Job/Subject: Knott Gate Farmhouse
Slaidburn

Job No: 5923
Date: 19 August, 2022

Responses to comments provided by the Planning Officer and Historic Buildings and Places from Heritage Consultant [REDACTED]

Proposed North West Elevation
Scale: 1:100

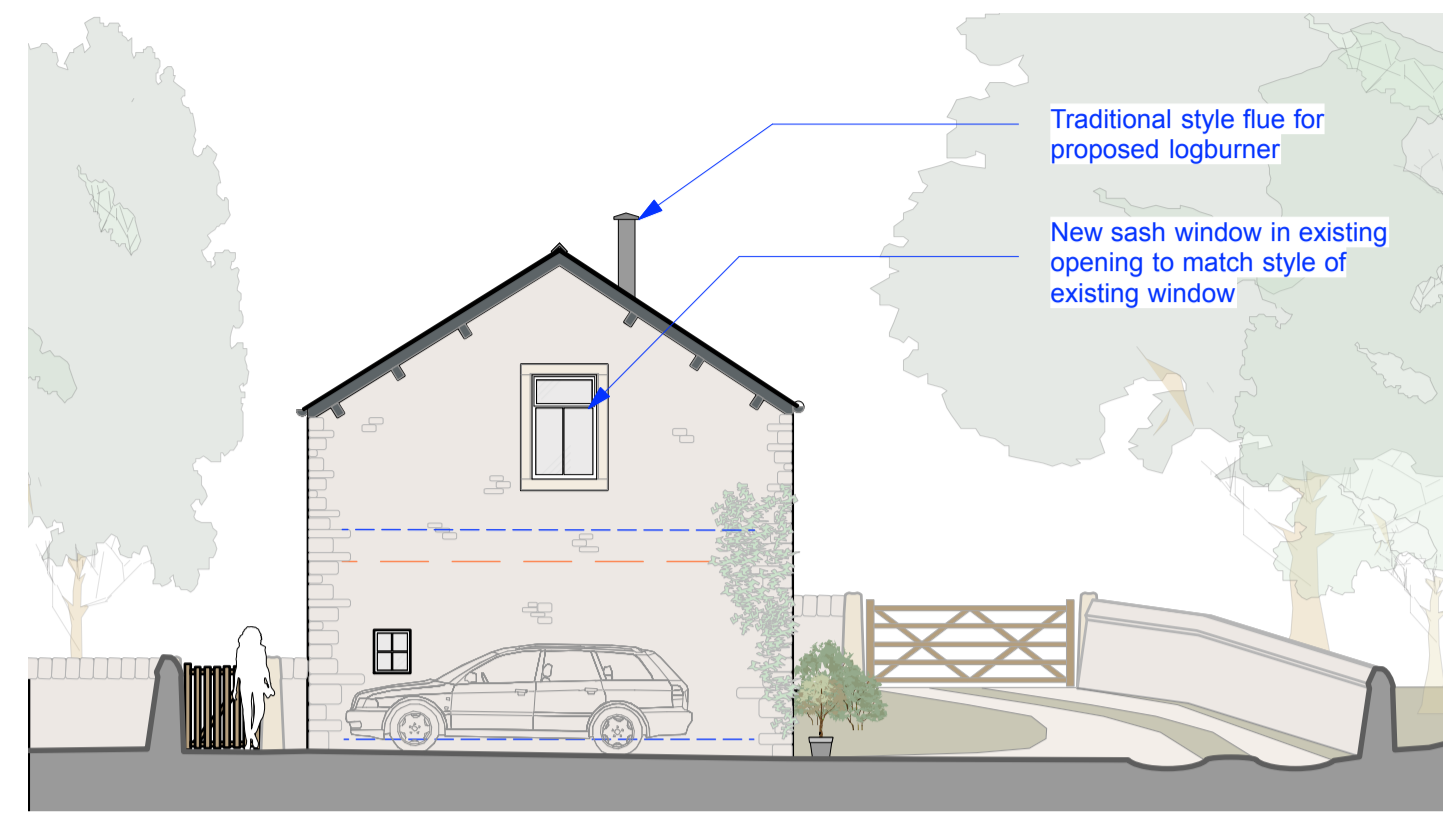
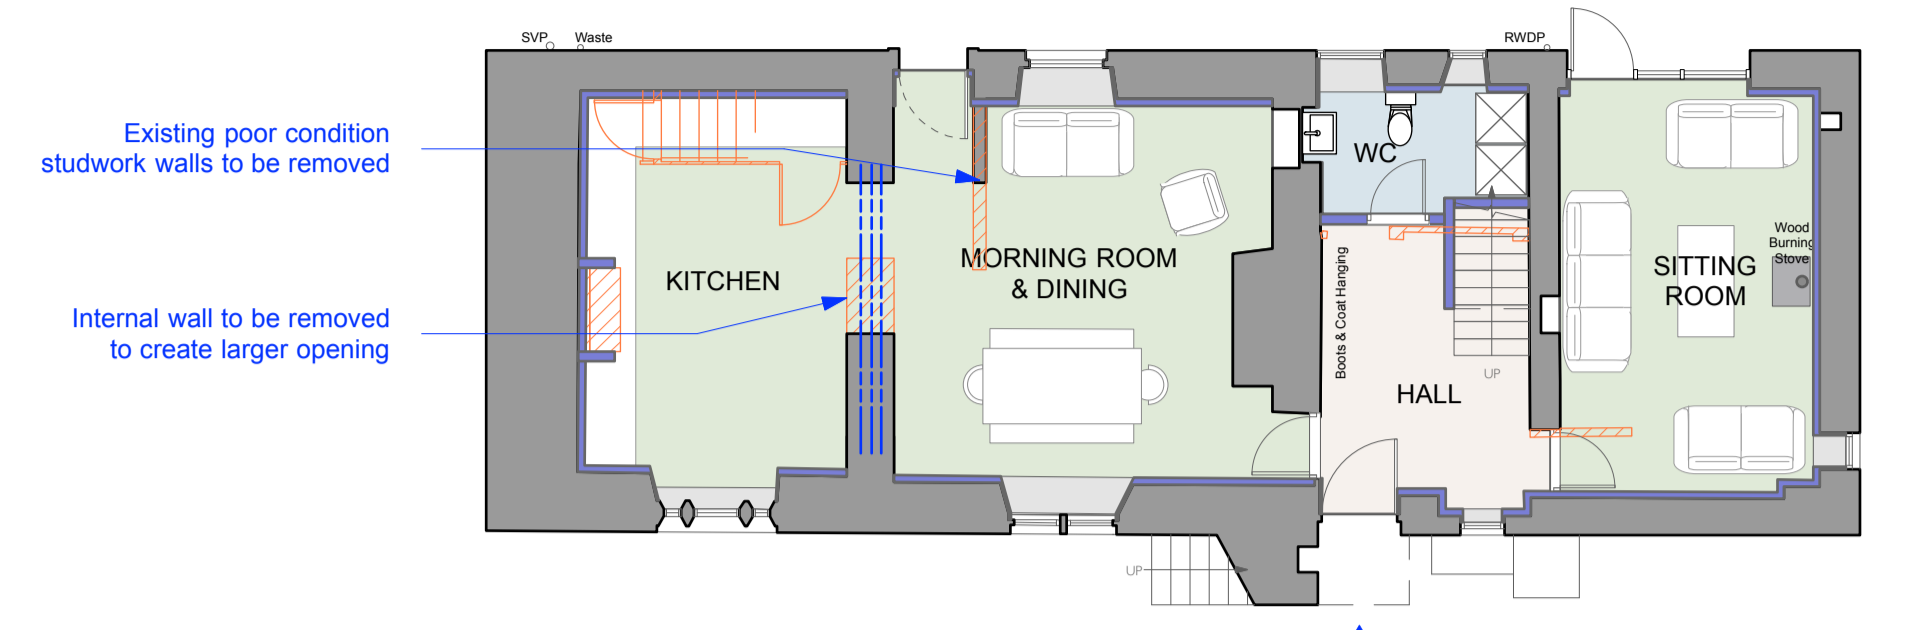
HBP “We also object to the proposed replacement of the stone slate roof with blue slate. Stone slate is endemic to the Pennines and Slaidburn in particular. While part of the building now has slate, the removal of the stone slate to the lower section would harm the interpretation of the building, and also to the historic townscape as a whole. The stone slate should be repaired for both this and the outbuilding.”

MGA comment - this has now been amended on our drawings, to reflect concerns.

Proposed Ground Floor Plan
Scale: 1:100

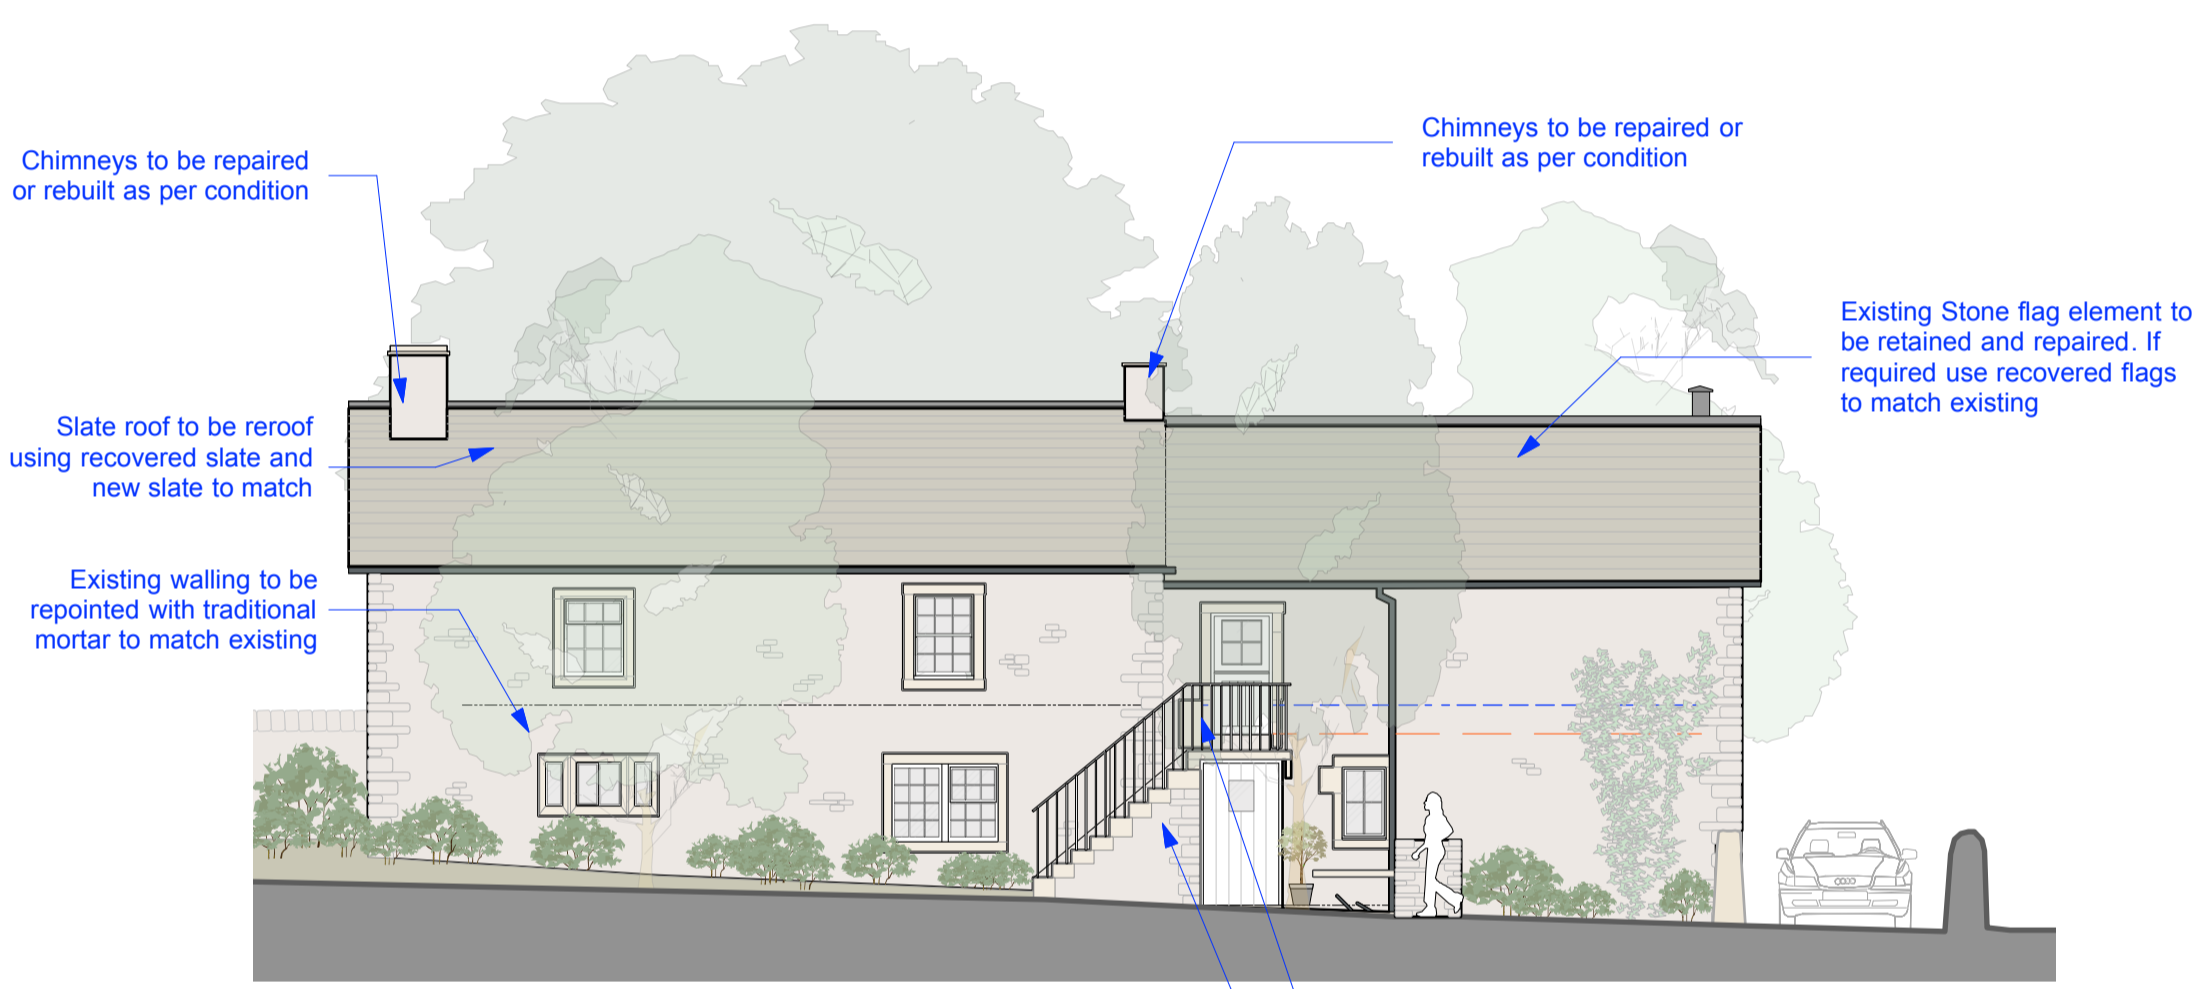
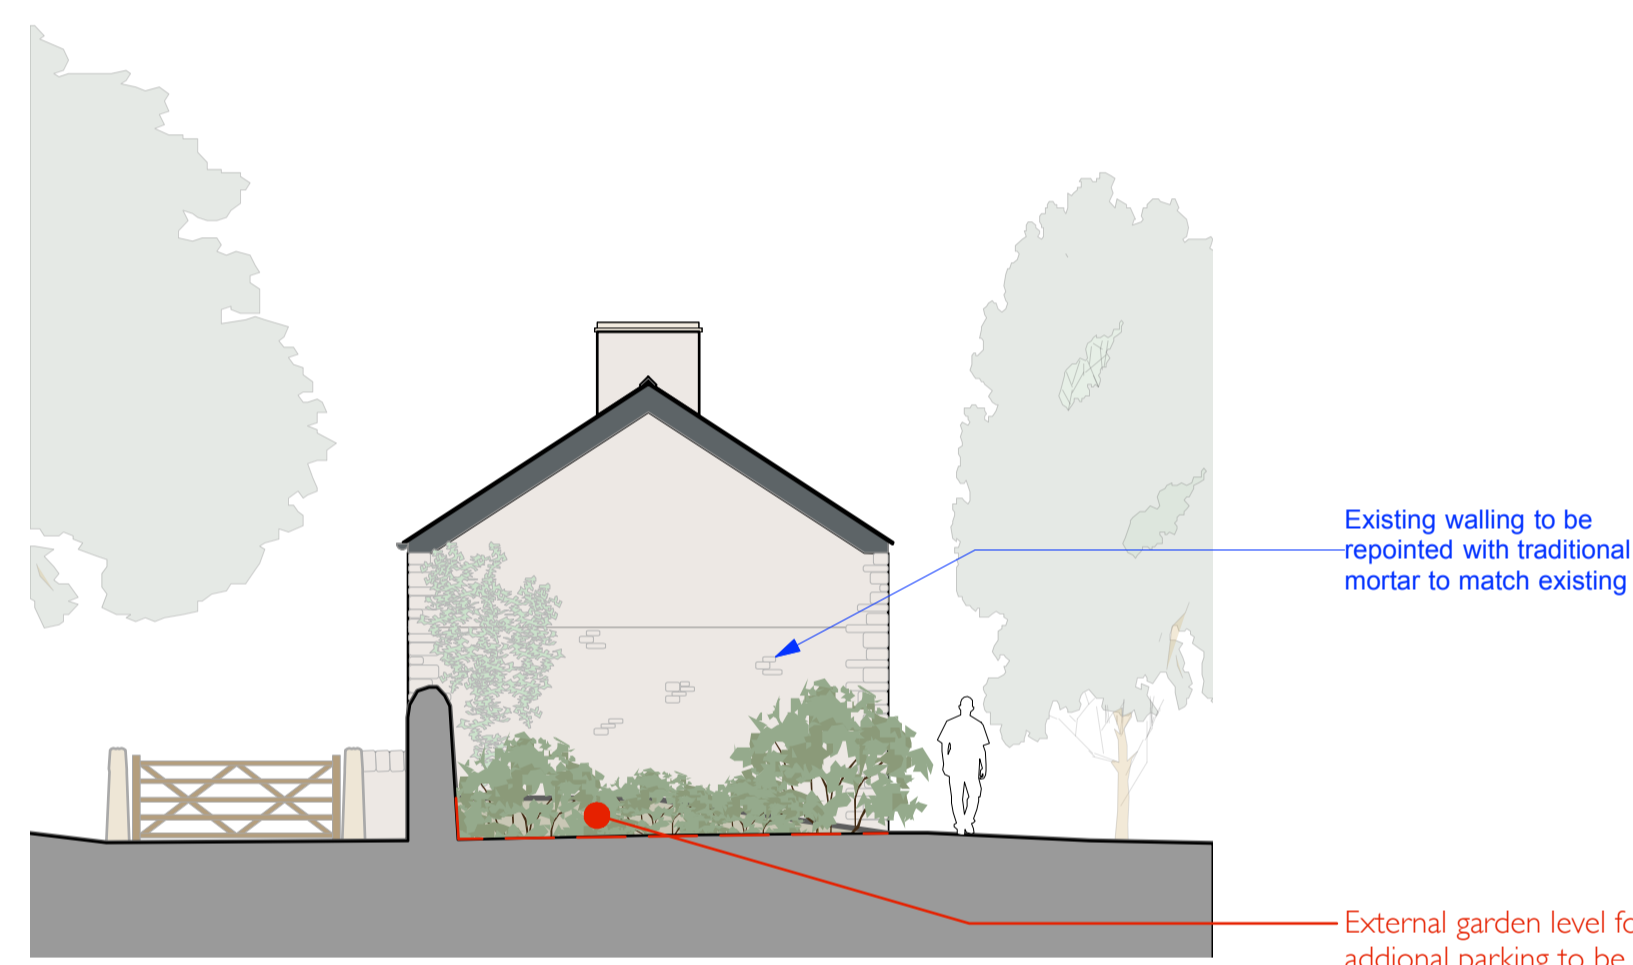
HBP “We object to the removal of the substantial internal wall between the kitchen and proposed dining room to create an open plan room. This appears to be an essential part of the original two cell planform. Its removal would be harmful to the understanding and reading of the building’s early to mid-17th century origins.”

We have calculated that this comprises a ‘Minor’ impact (proposal K, p83; we note that retaining the wall stubs retains some legibility)

Proposed First Floor Plan
Scale: 1:100

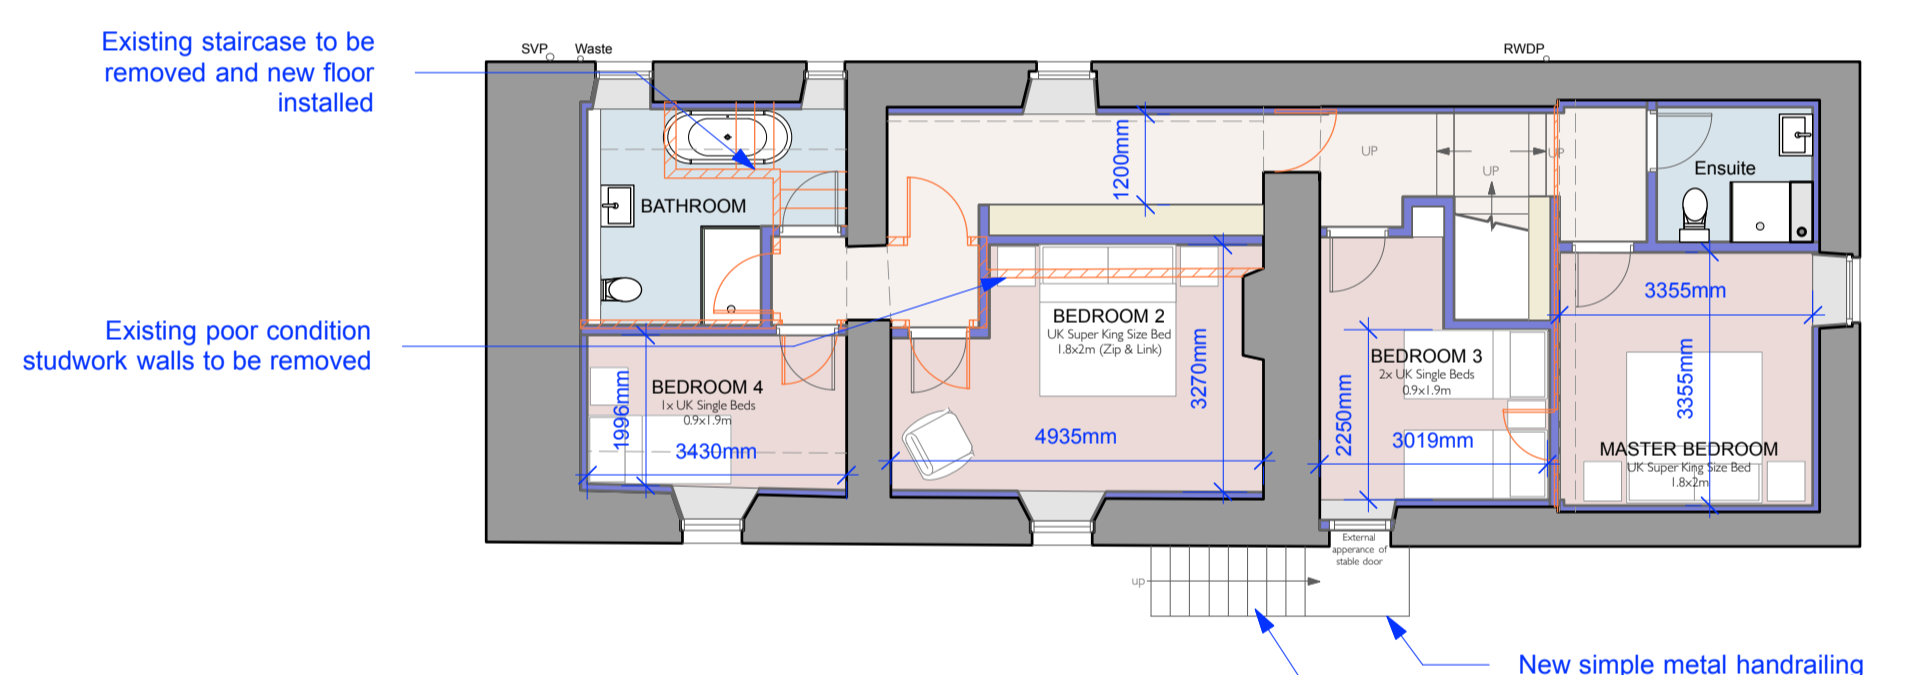
HBP “The loss of a historic stair would also be a concern and we suggest further investigations are needed to establish its significance.”

We’d said in Section 4.2.9 that “It is not clear whether the internal staircase is original, and access up may originally have been via a staircase in the centre, or via a ladder.” – while the staircase could conceivably be original, the photos (Plates 11-12) suggest that the stud walls and timber used are much more recent. It could occupy the original position of a 17C staircase, or it may not. Further investigation would in my view likely establish that the staircase is 19C in date. Stairs in the corner like this are less frequent in my experience than the central ones for a 2-cell building – but that access to the first floor was initially made via a ladder access is also possible.
